Ms Prity Cleary
Senior Planning Officer
Social Other Infrastructure Assessments
NSW Department of Planning, Industry and Environment
Locked Bag 5022
PARRAMATTA NSW 2124

Notice of Exhibition of Fort Street Public School (SSD 10340) - Comments on Environmental Impact Statement

1 SECTION Section At Bldg A
1:200

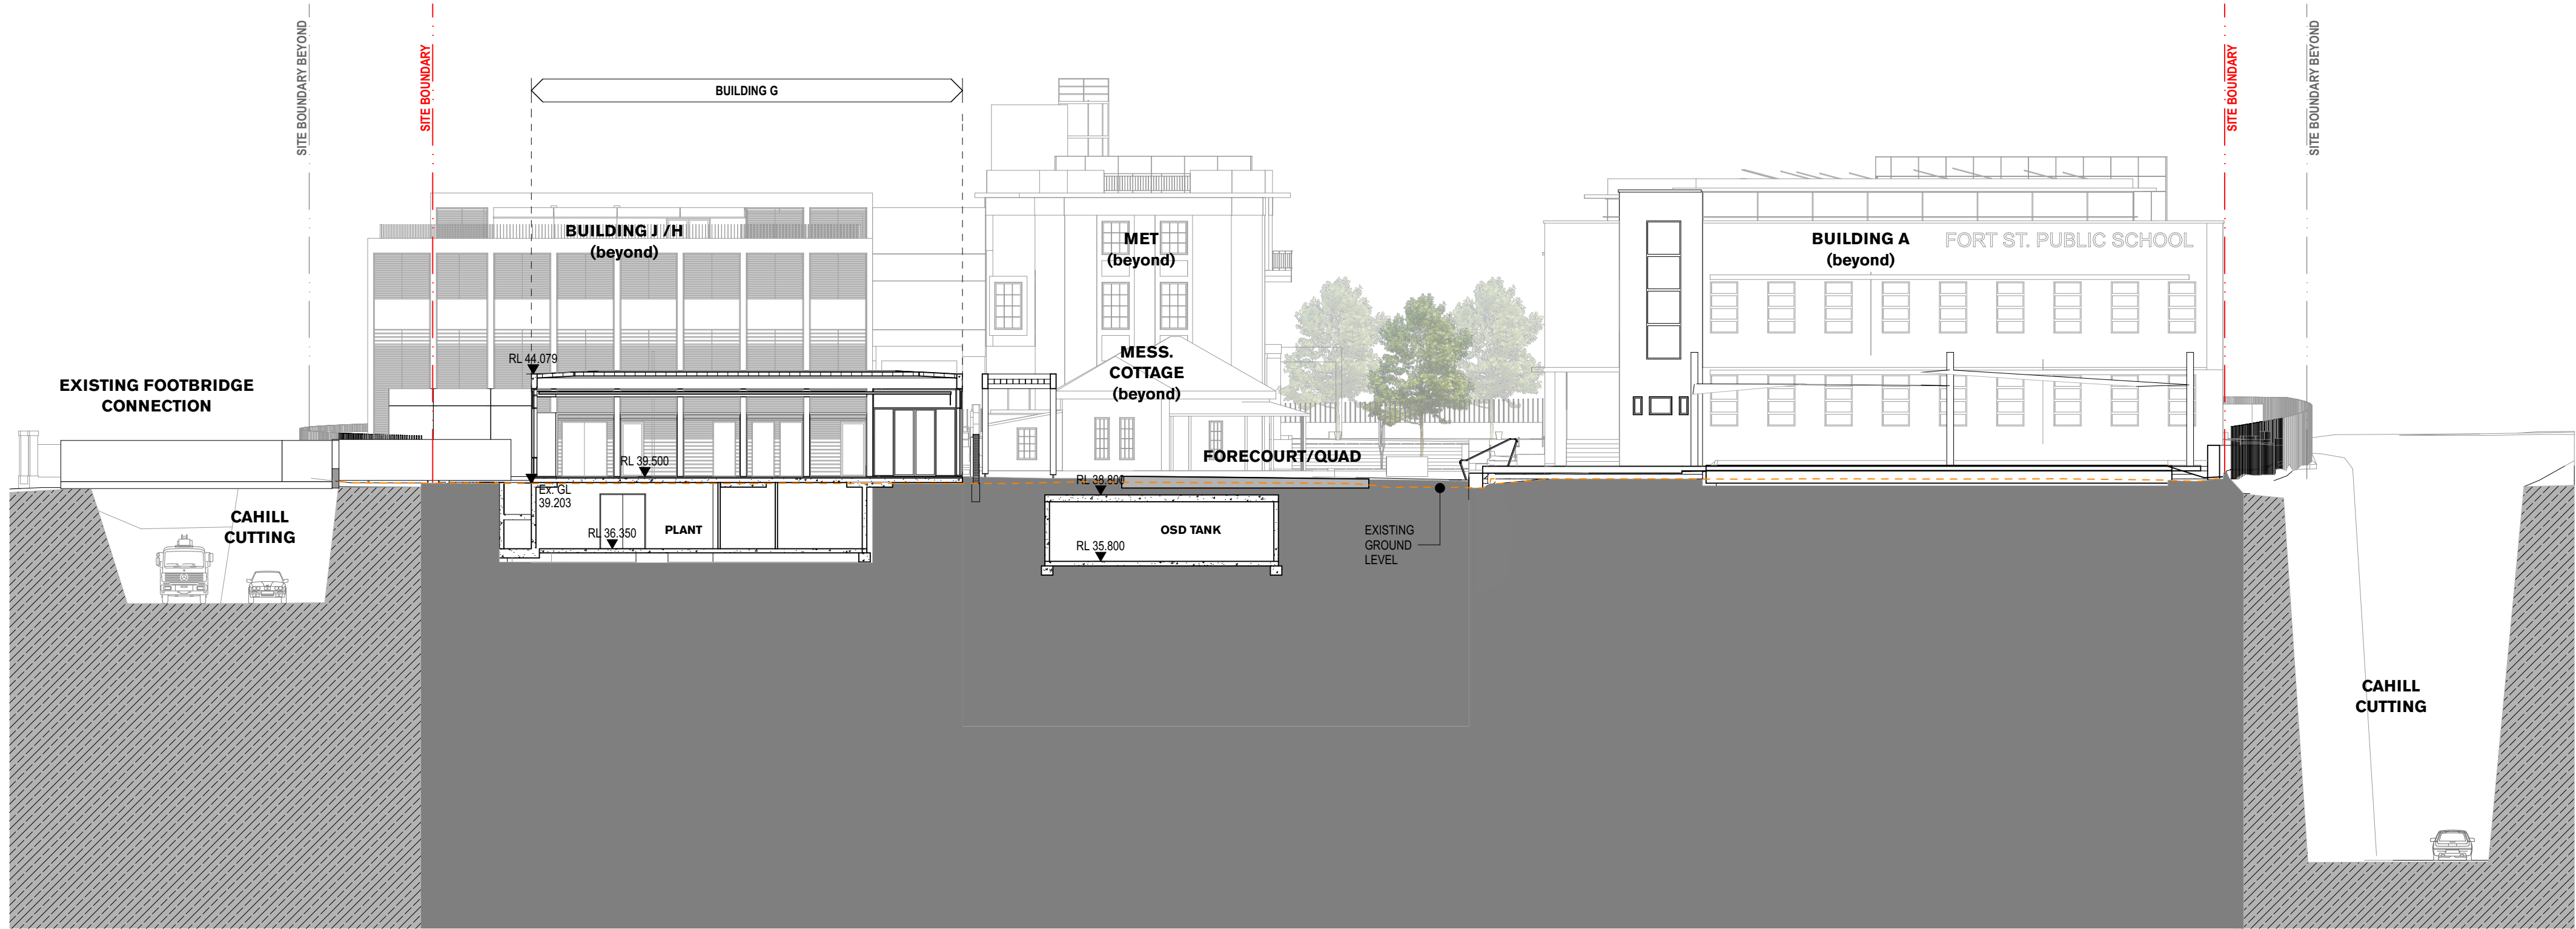
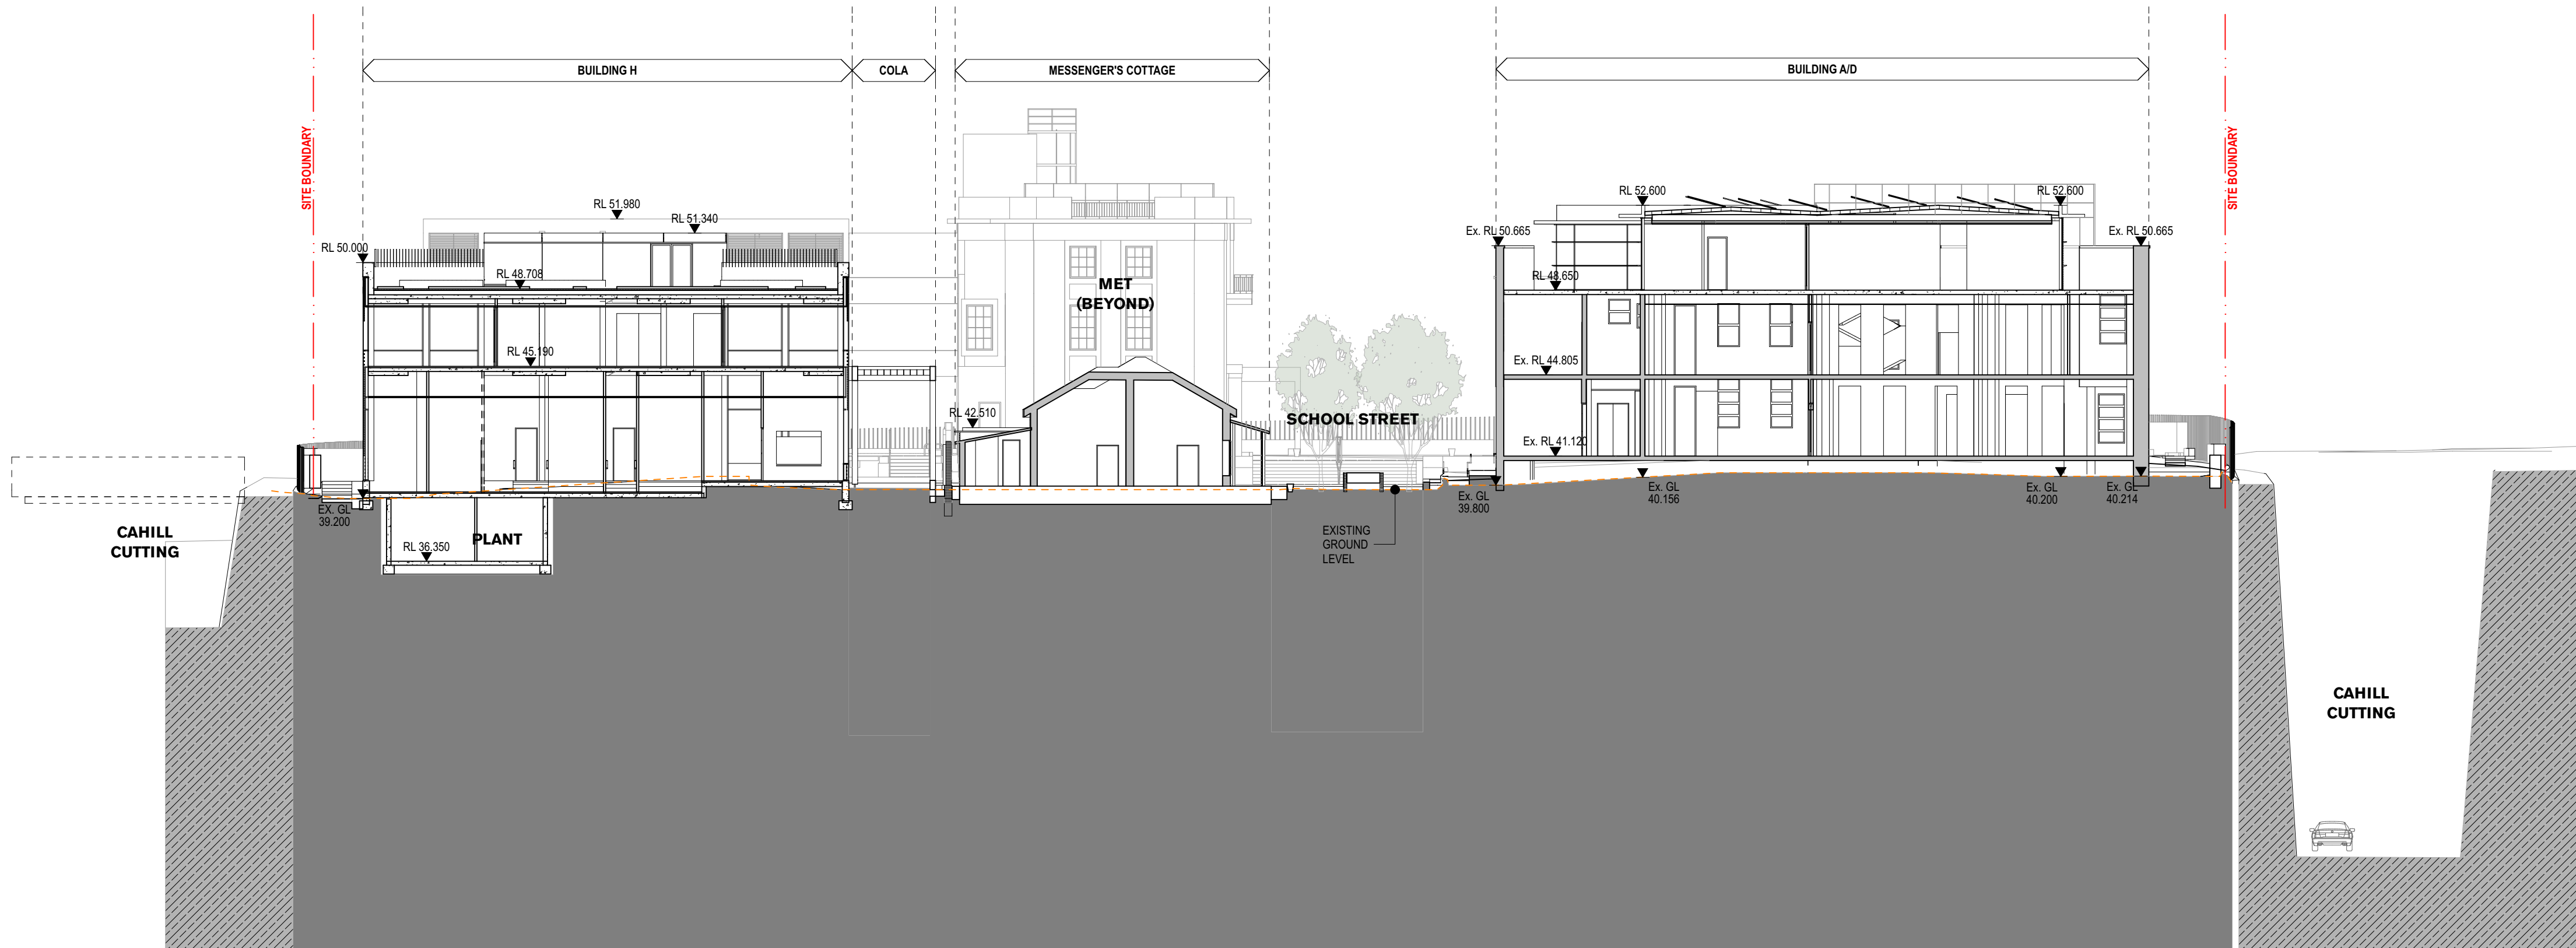
- The 2020 CMP responds to the significance assessment (including the significance grading of spaces) of the Fort Street Public School (1941) designed by the significant architect, Harry Rembert of the Government Architect's Branch (NB. this building is identified as Building A in this SSDA). However, we recommend that the CMP include more detailed discussion of, and guidelines for, permissible alterations (external and internal) and additions (vertical and horizontal) to this exceptionally significant building. Without such assessment, discussion and guidelines, we are unable to comment on the appropriateness or otherwise, of the proposed internal alterations and additions (vertical and horizontal) to Rembert's school building. We also consider the Heritage Impact Statement to be inadequate in its assessment of heritage impact of the proposed changes to Rembert's school building (including the new roof and photovoltaics).
